**RE: Coyote Gravel Inc. Secondary Site
Albuquerque, NM
Traffic Impact Study (M14D041)
Response to Comments**

The Final Traffic Impact Study is being transmitted concurrently with this letter of response to comments. Per the correspondence with Curtis Cherne dated January 24, 2025 and Julie Luna dated February 11, 2025, please find the following responses addressing the comments listed below:

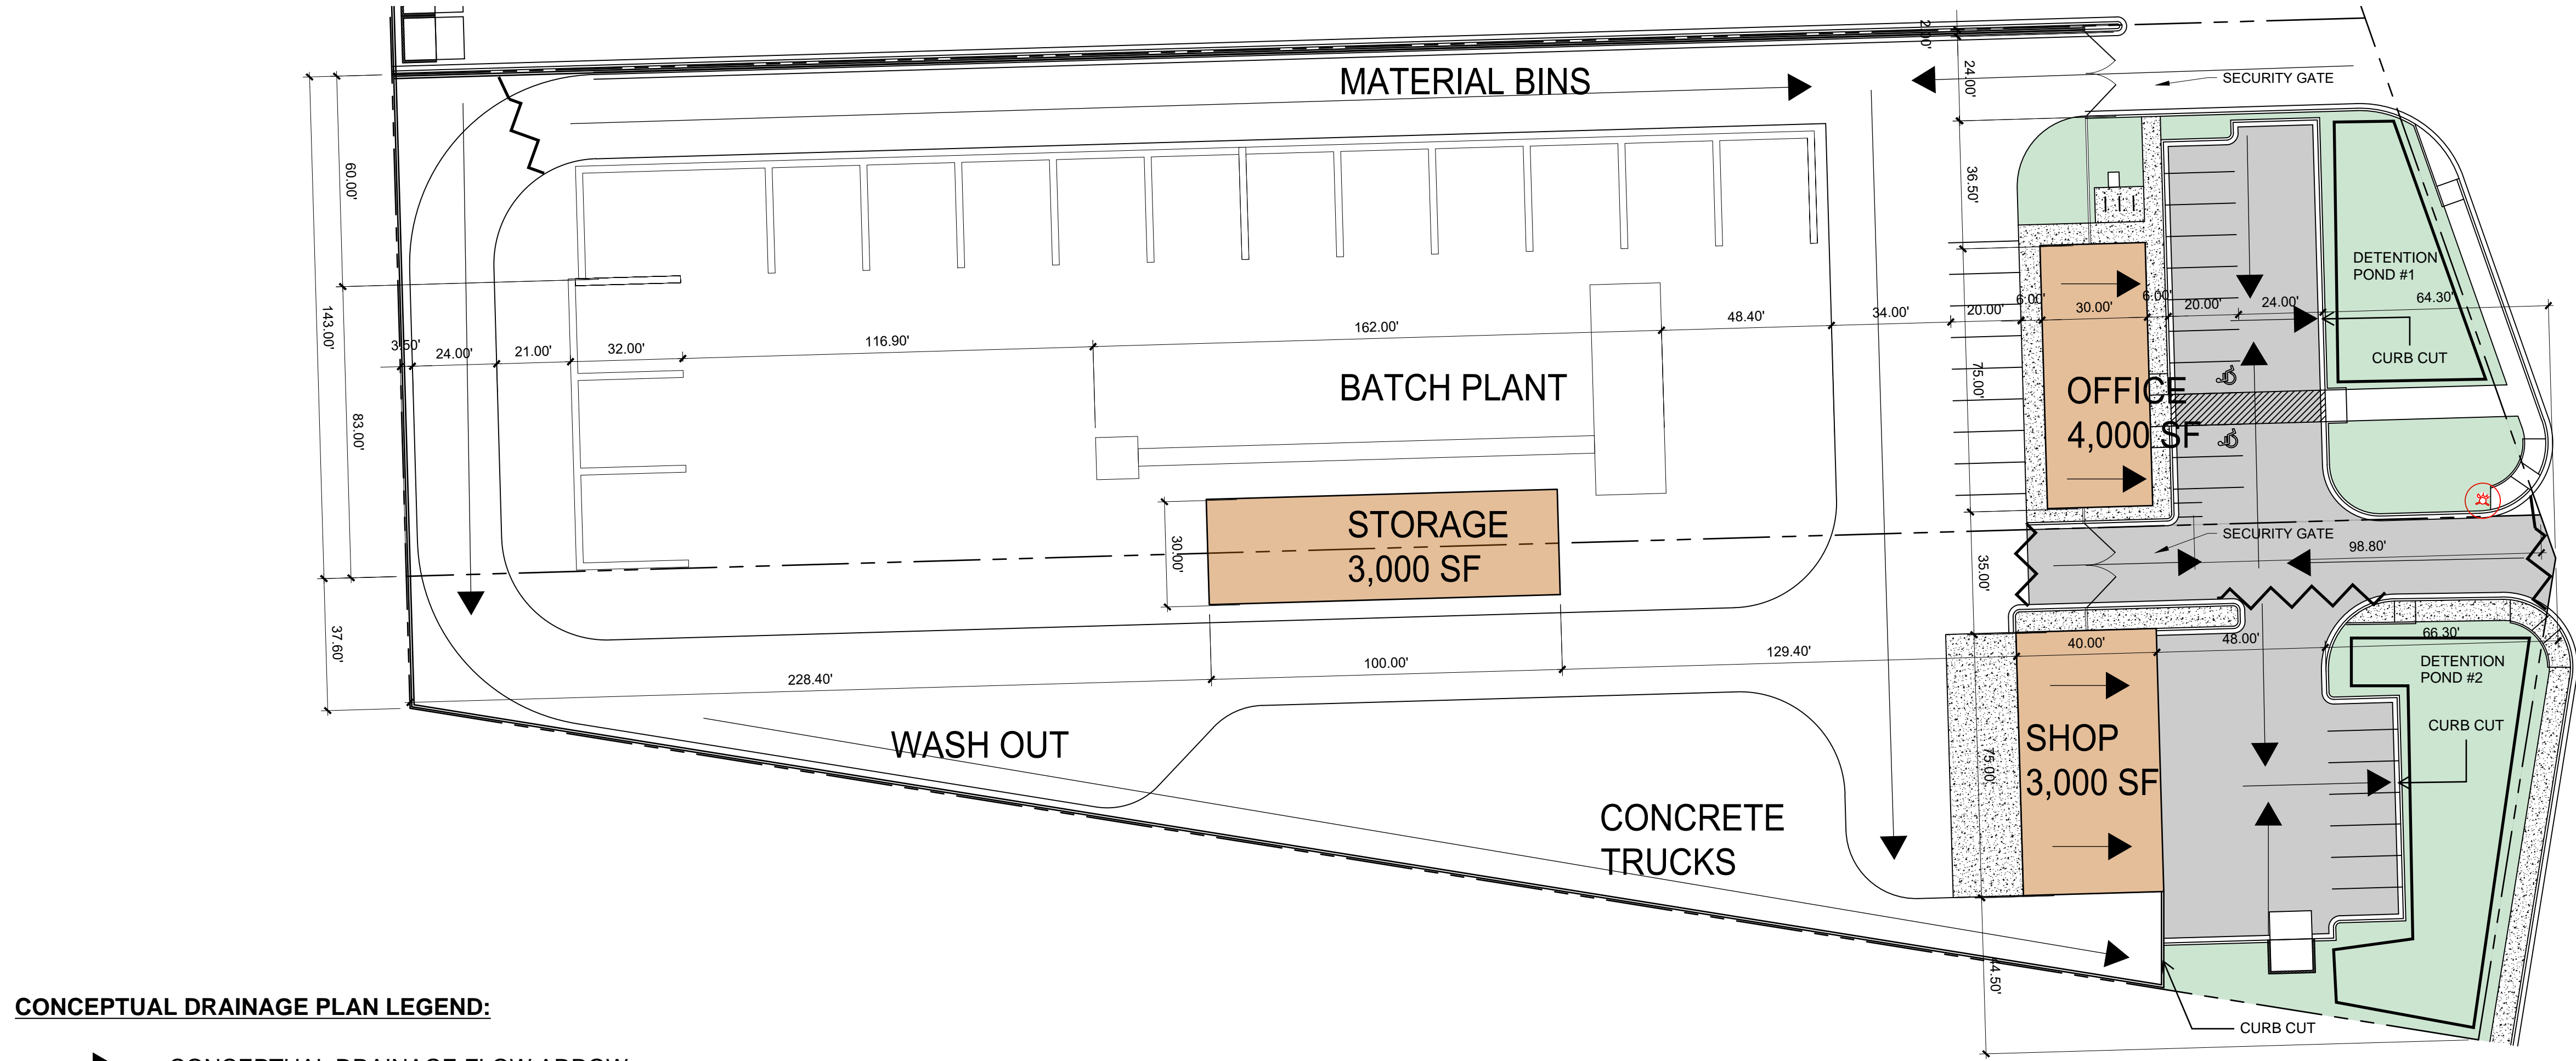
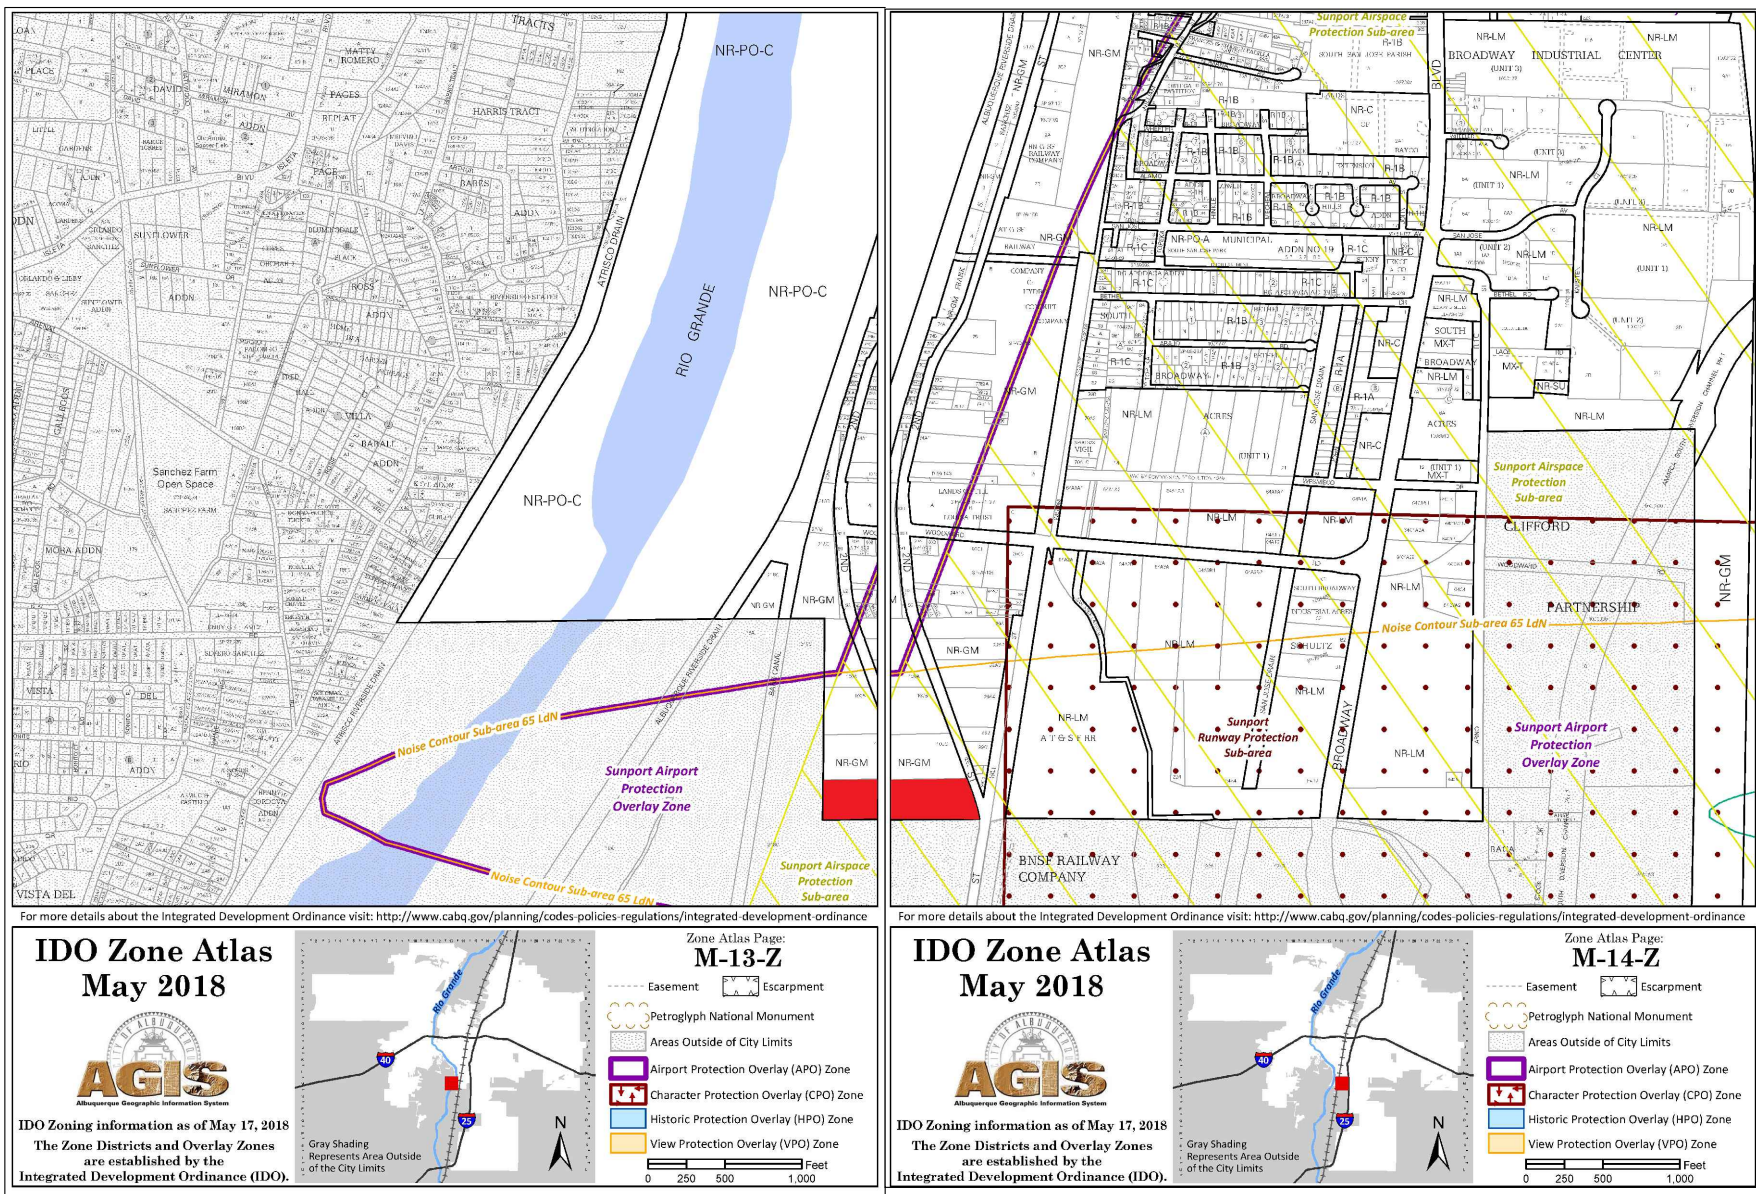
- a. Include a plan that shows the site Plan(s) on one 11"x17" sheet including the entire street and driveways and buildings/driveways across the street for relevance. Locations of driveway(s) is important.
- b. The Vicinity map appears to show this project south of City Jurisdiction. Is some of the project outside City limits?
- c. The DTIS states there are two lots of approx. 6 acres, while the Study states approximately 9.3 acres. BernCO database agrees with the approx.. 6 acres. Where are the other 3.3 acres coming from?
- d. The Site plan on page 5 shows the site straddling 2 lots. One lot would be outside City limits. How will you permit a project with a jurisdictional boundary down the middle?
- e. Site Access on p.8 provides a distance for Driveway A from Woodward Rd and for Driveway B from Rio Bravo Rd. How far are the driveways apart? Demonstrate on a Site plan.

- a) *Site plan has been added to the report and the appendix.*
- b) *Yes, there are ultimately two projects. One inside of the City of Albuquerque (COA) jurisdiction and one inside of the Bernalillo County (BC) jurisdiction.*
- c) *There are three total lots that this development will span. Two lots are located within the COA and one lots is located within the BC jurisdiction. The legal descriptions and acreage of said lots is as follows:*
 - i. *MRGCD Map #44 TR 100-C = 3.18 Acres*
 - ii. *MRGCD Map #44 TR 100-D = 3.1168 Acres*
 - iii. *TR 2 PLAT of TRACT Lands of Good Cents Inc = 1.3032 Acres*
- d) *The two projects will be permitted separately, one with the COA and one with BC permitting processes.*
